From: Debi <wranglermissy@gmail.com>
Sent: Thursday, January 23, 2020 9:09 AM
To: Ryan Howser
Subject: Re: 1st time notice of File: AL201 Admin Special Use Request

We just received your documents on 1/18/20 RE: Administrative Special Use Request for Harper Accessory Living Quarters for "permanent occupancy" to our adjacent property we own. This is the "first notification" to this matter we have received so here are our comments, questions and concerns.

CUSTOMER: HARPER, BARRY  
ADDRESS: 13645 GYM KHANA RD,  
LEGAL: LOT 10, CORRAL RANCHES, SUBDIVISION  
TAX ID: 4329001016  
ACRES: 8.33  
SCHOOL DIST: 49, FALCON

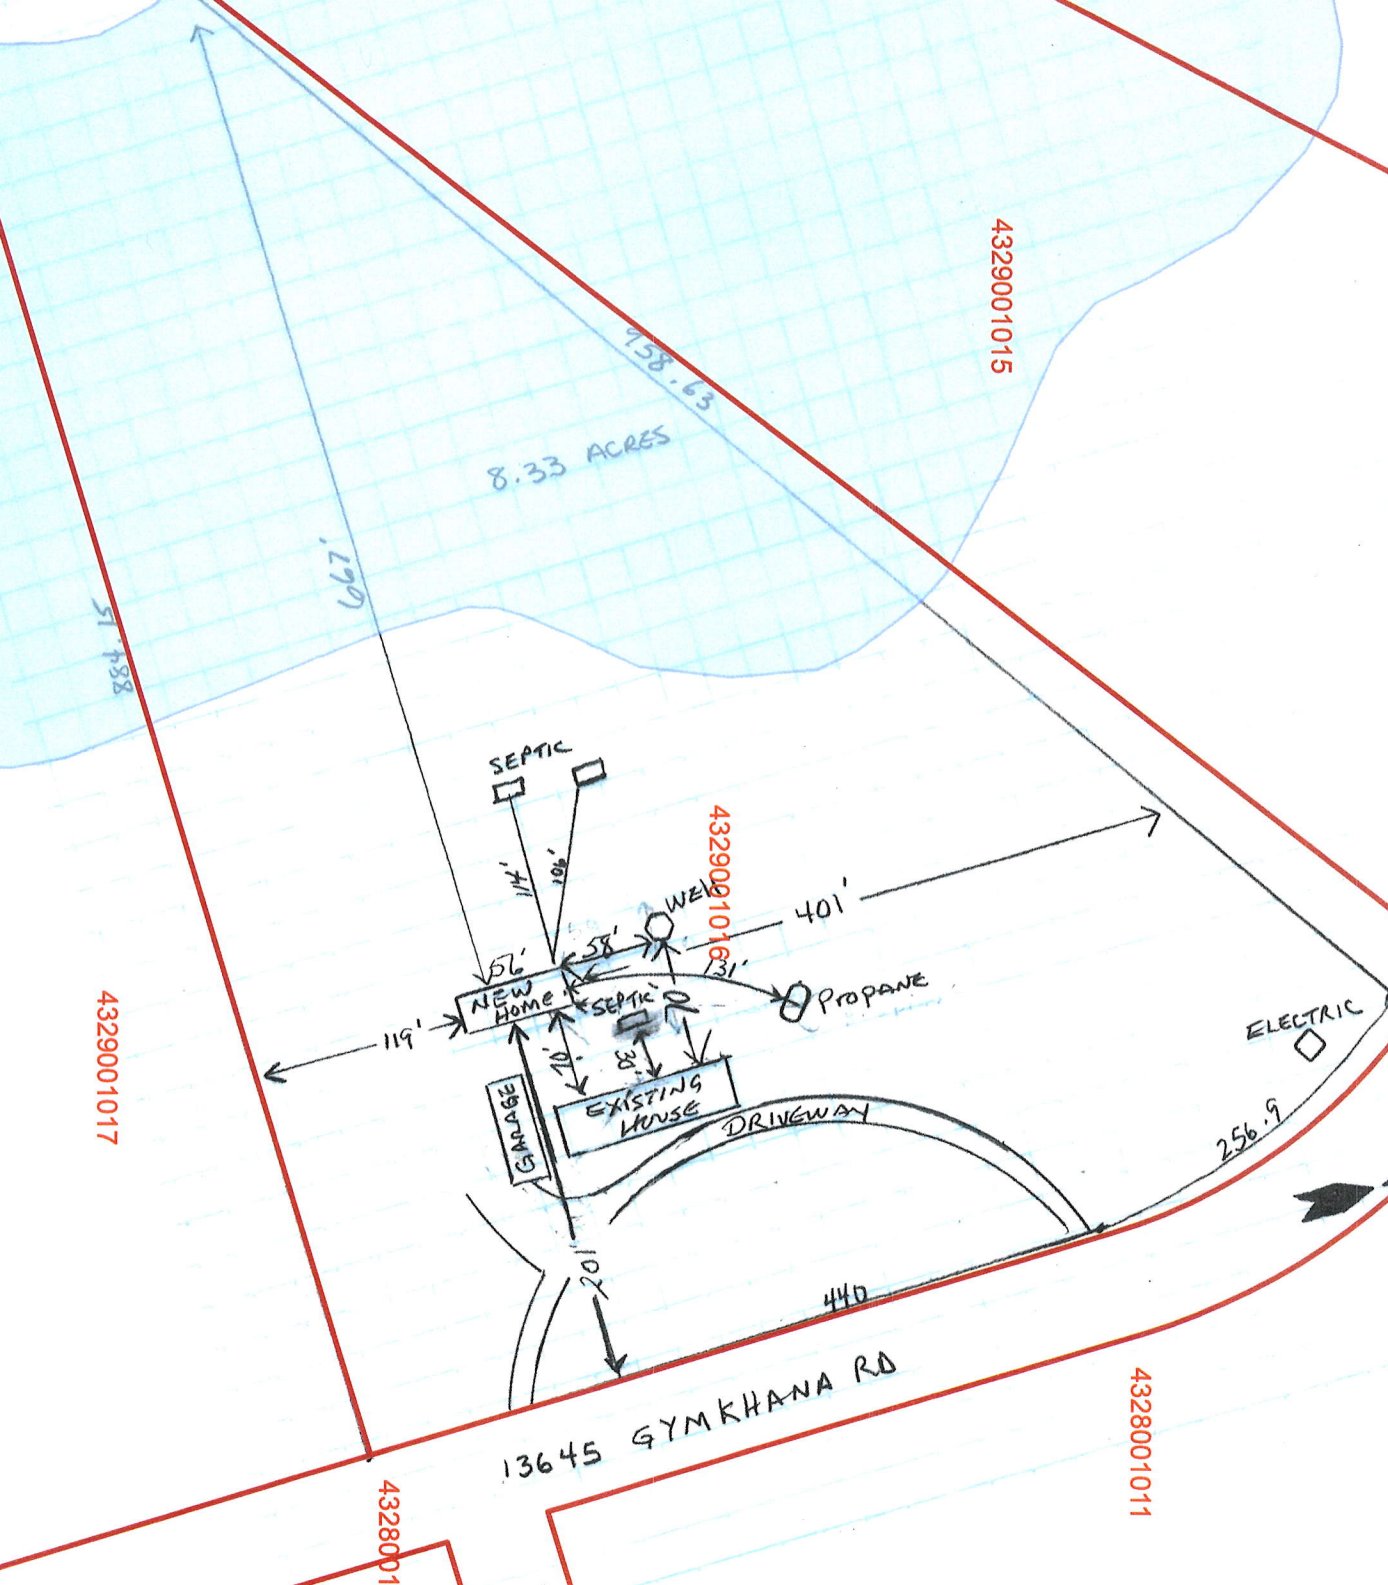
Is that Septic system up to code by the "amount of bedrooms" both of those homes will be using if using only one system now and in the future or then they should be putting in an entirely separate system for that new home, seems our neighbor had to put in a new system for just adding on ONE bedroom to his existing home.

I have downloaded the other attached documents from your site regarding the File and that seems to be a sizable manufactured home they are placing right behind their original home.

We are extremely concerned of any additional "permanent living quarters" where an existing home already is on that property. Then why can't everyone on (R2-R5) Rural small acreage just haul in a manufactured or trailer homes on their property for two family residential use? Or can we? It would be good extra income for everyone. The home will take extra well water and septic use or do they have to put in a separate well and septic? They will probably just tap off same electric and LP tank.

Specifically, just to make sure you are aware of what is being asked for, it is not for a second house on the property, but simply what we call "accessory living quarters." This is for an immediate family member only, and they are required to provide an affidavit to be recorded prohibiting the structure

from being rented. As you indicated, when the accessory living quarters is no longer needed, the structure will either need to be removed or converted into a guest house, again, not to be rented.

The intent of the special use process regarding this type of project is to prevent there from being a second house on the property for rental or permanent stay, such as in the examples you provide below. The only way that a project like this can be considered for permanent residency is for an immediate family member with a medical hardship. This is not a rental unit and it is not a second house for another family to stay in. It's limited to 1,500 sq. ft. for a family member and they cannot create separate utility billing for it.
